Jean Fraser - 421 Warren Avenue

From: Tom Errico <thomas.errico@tylin.com>
To: Jean Fraser <JF@portlandmaine.gov>
Date: 5/22/2014 12:08 PM
Subject: 421 Warren Avenue
CC: David Margolis-Pineo <DMP@portlandmaine.gov>, Katherine Earley <KAS@port...

Jean – The following represents my final comments and are presented as a status update of my March 12, 2014 preliminary comments.

WB-67 AASHTO 2011 (US)

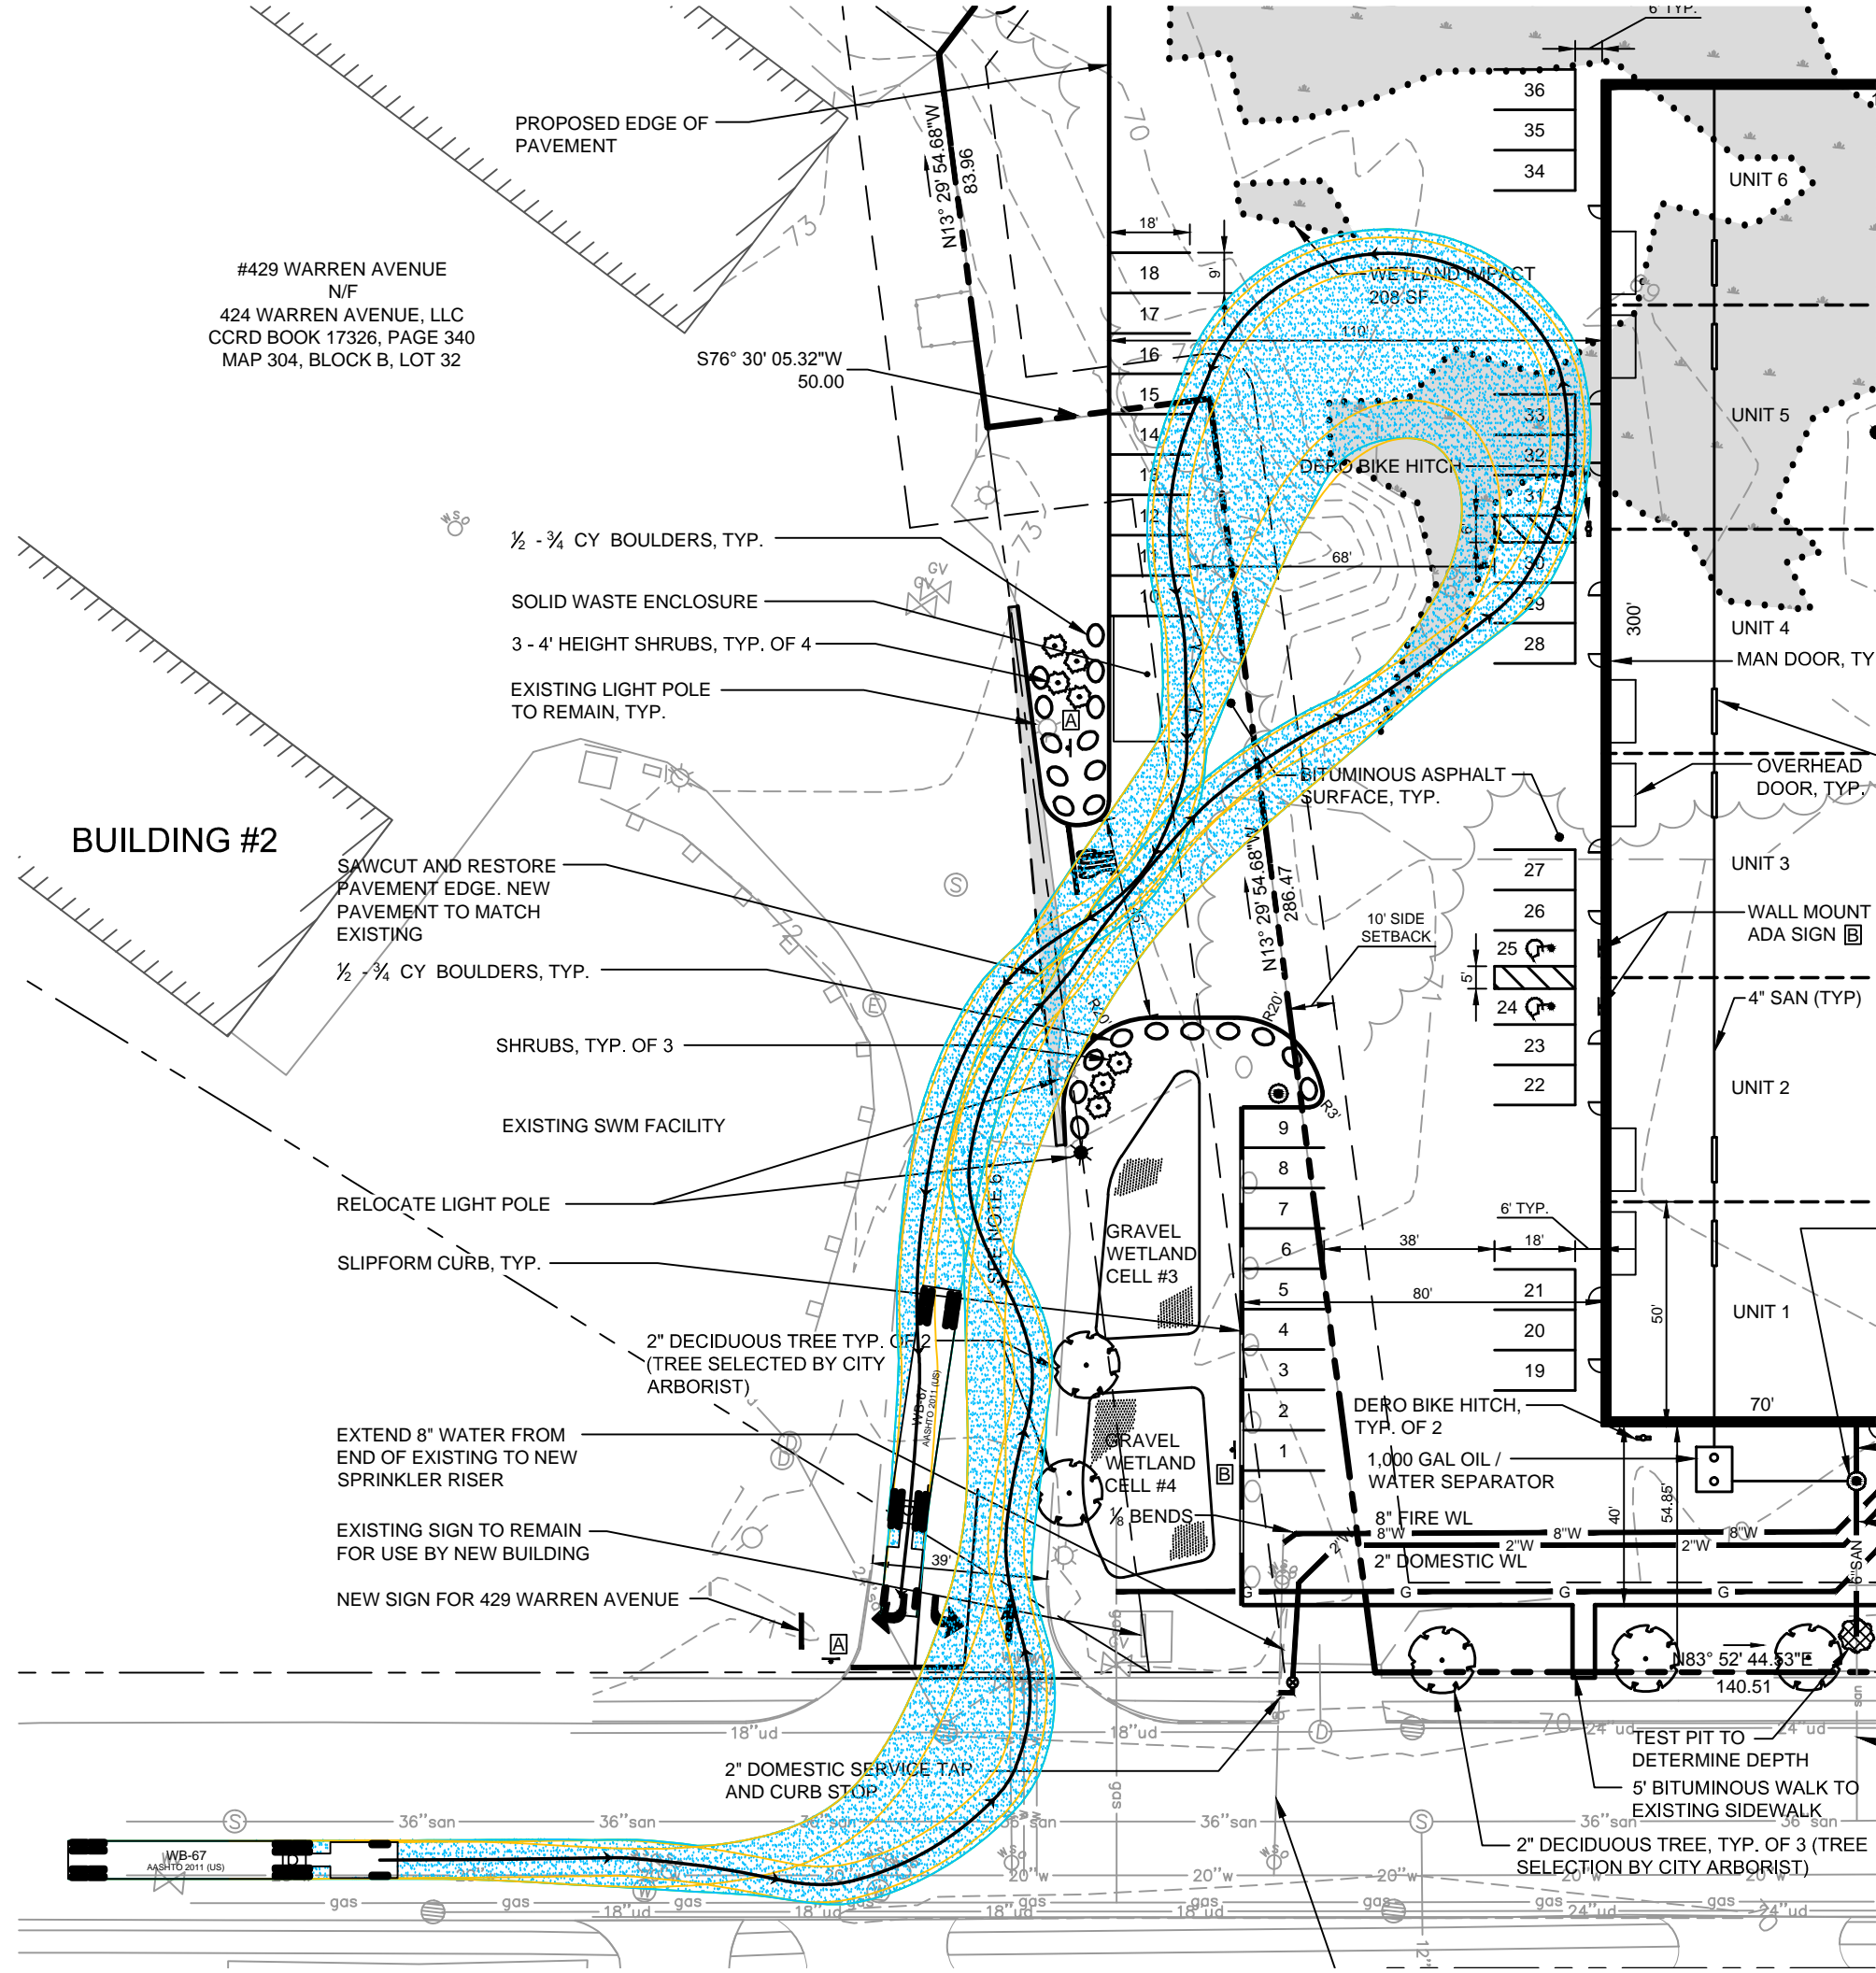
Jean - I have reviewed the Auto-Turn graphic provided by the applicant and given what they illustrate, there seems to be a substantial amount of pavement that could be removed on the north end of the parking lot. I would note that the Auto-Turn graphic that is provided in the application materials only illustrates a WB-67 size truck entering and exiting the driveway. It is unclear on what type of loading dock maneuvers will be required and whether this type of truck circulation will require additional pavement needs. The applicant should provide the additional information if deemed relevant.

- **The applicant has provided a truck turning template graphic that shows a significant portion of the parking lot will be required for very large truck maneuvers. The graphic also illustrates that the trucks will require use of areas that are noted as general passenger car parking spaces. From a traffic perspective the paved area will not present safety or circulation problems. The applicant will need to coordinate closely with tenants to ensure parking areas will not constrain large truck maneuvers. It is my understanding that the applicant has experience managing this type of situation. Given that the site is somewhat contained and is set back from Warren Avenue, I find conditions to be acceptable and support a waiver for parking lot aisle width.**

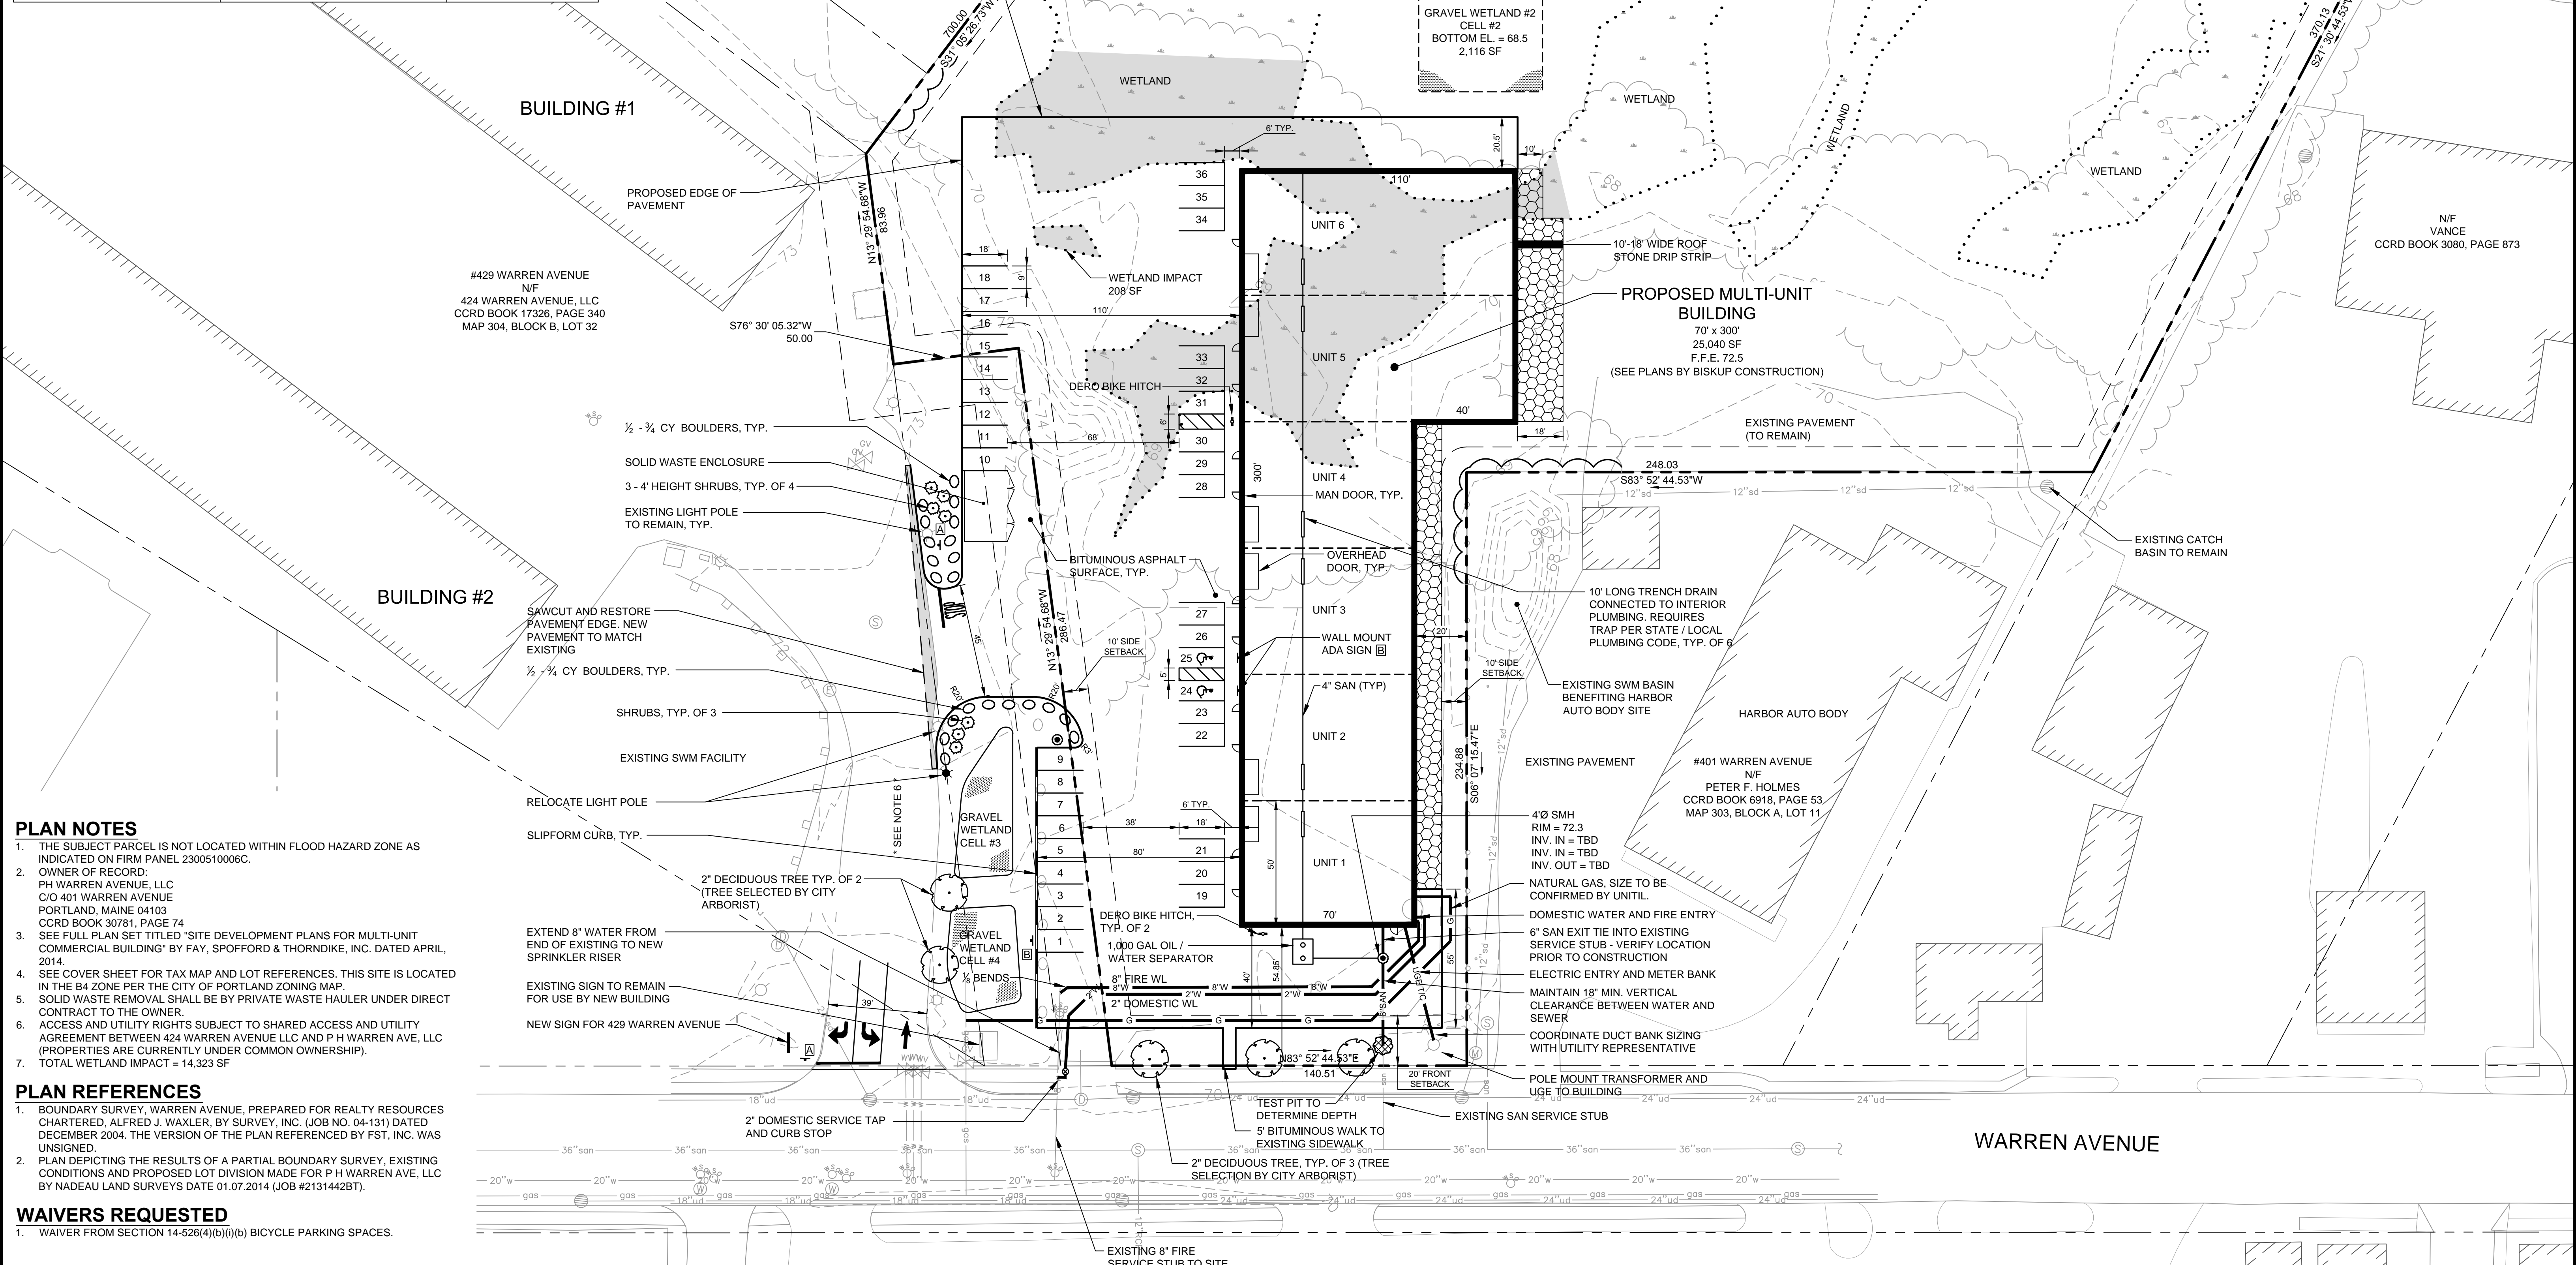
- The proposed driveway entrance exceeds City standards and a waiver will be required. The applicant shall provide an Auto-Turn analysis documenting the need for the wide driveway.

- The aisle widths in the internal parking/circulation area do not meet City standards and a waiver will be required. The applicant shall provide an Auto-Turn analysis documenting the need for the expanded pavement areas.

- A sidewalk connection from the proposed building to Warren Avenue shall be provided.
 - **The site plan has been revised to include this and therefore I have no further comment.**

- An area along the building frontage on the parking area shall be marked such that pedestrians have a direct routing to Warren Avenue.
 - **The plans should be revised to include this painted area.**

- **Status - In response to this comment, the applicant has reduced the size of the driveway. The revised driveway width continues to exceed the City's standard. Based upon a review of a truck turning template graphic, I find the proposed driveway design to be acceptable and therefore I support a waiver from City standards.**
